From: [REDACTED]
Sent: 31 July 2019 11:12
To: Maria Tomalova <Maria.Tomalova@arun.gov.uk>
Subject: Re: FP/139/19/OUT, Land south of garage compound

FP/139/19/OUT, Land south of garage compound BLOCK PLAN 1:200 scale

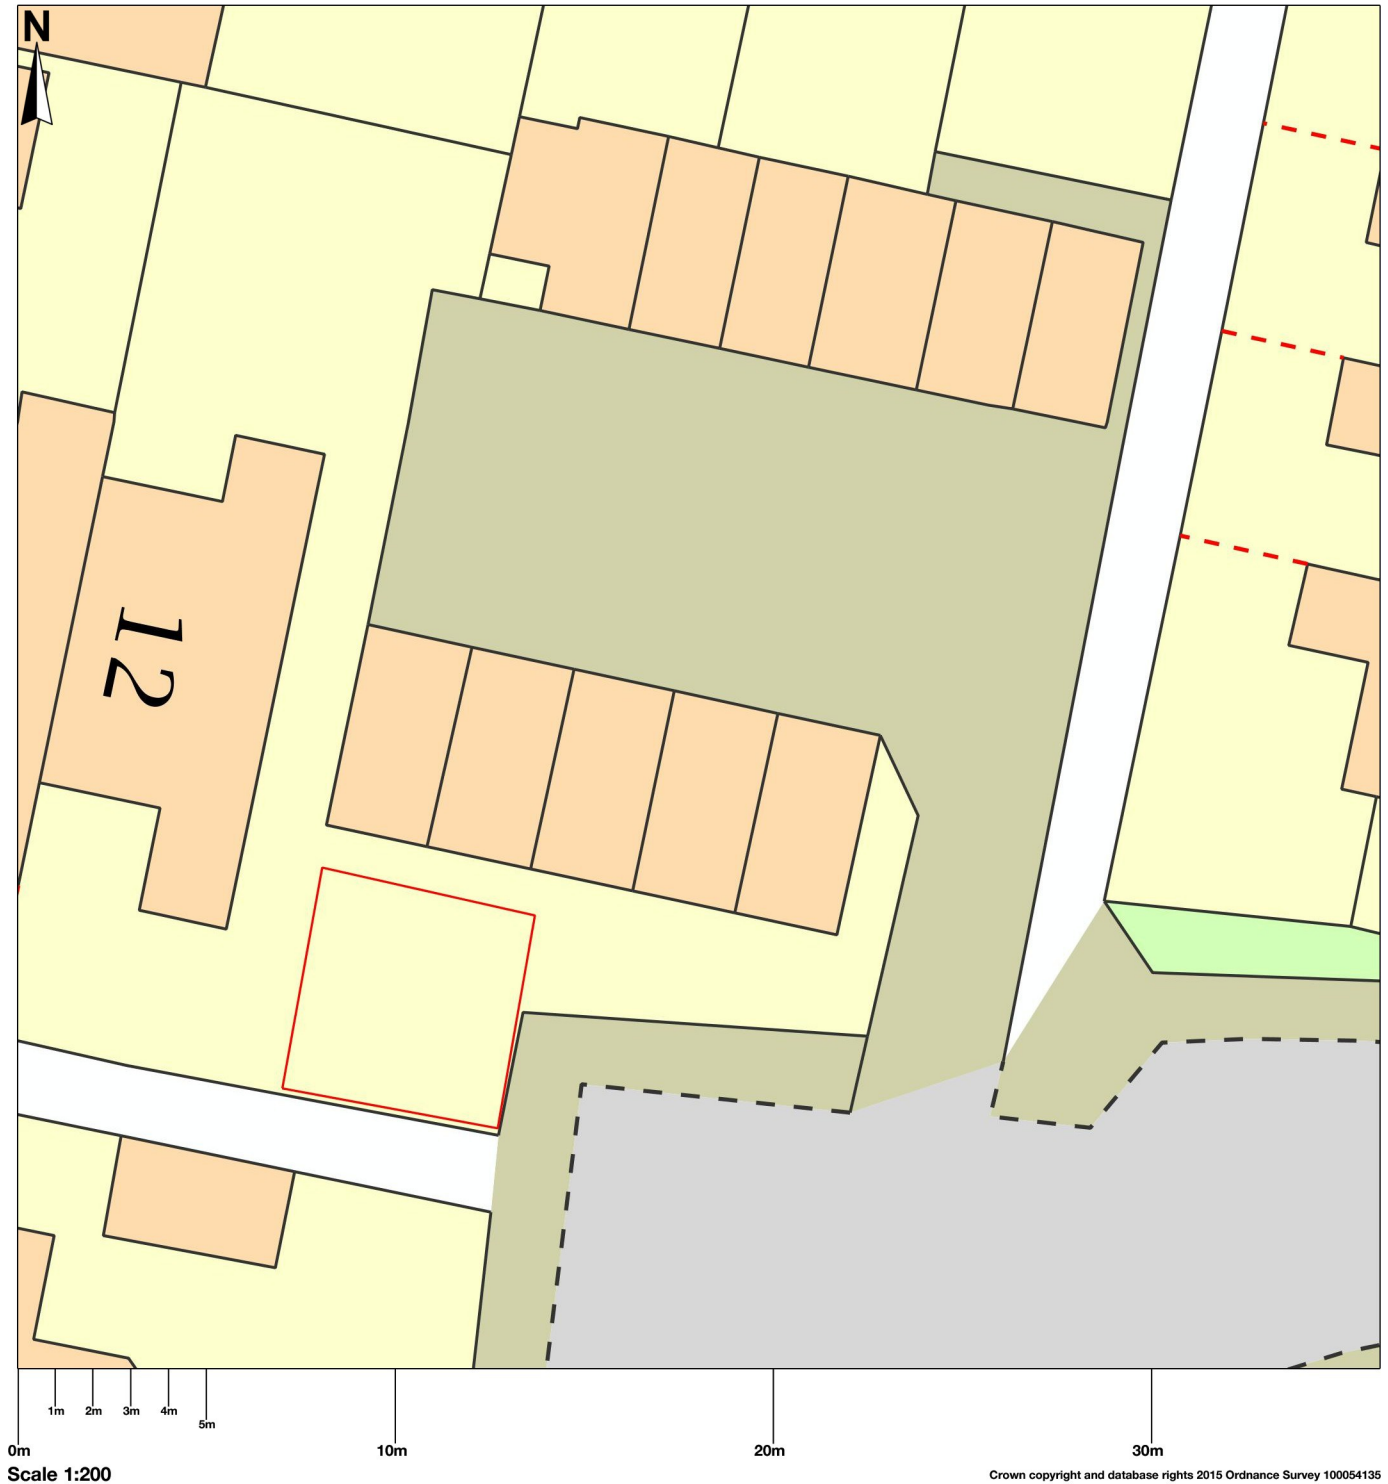
There appears to have been a misunderstanding of the original block plan, in that the building would cover the footway and prevent its use. The email to you from Nicola Fry and numerous other objectors seem to have gained this impression which appears to be growing in momentum but the premise is not correct!

Equally that the building would not impact on either of the trees and will deliberately avoid them.

The single storey dwelling, outlined in red, is approximately 6X6.5m internal floor area plus storage and at 39m2 this conforms to the minimum standard for one person, one bedroom (in addition only a shower is envisaged 37m2 is required).
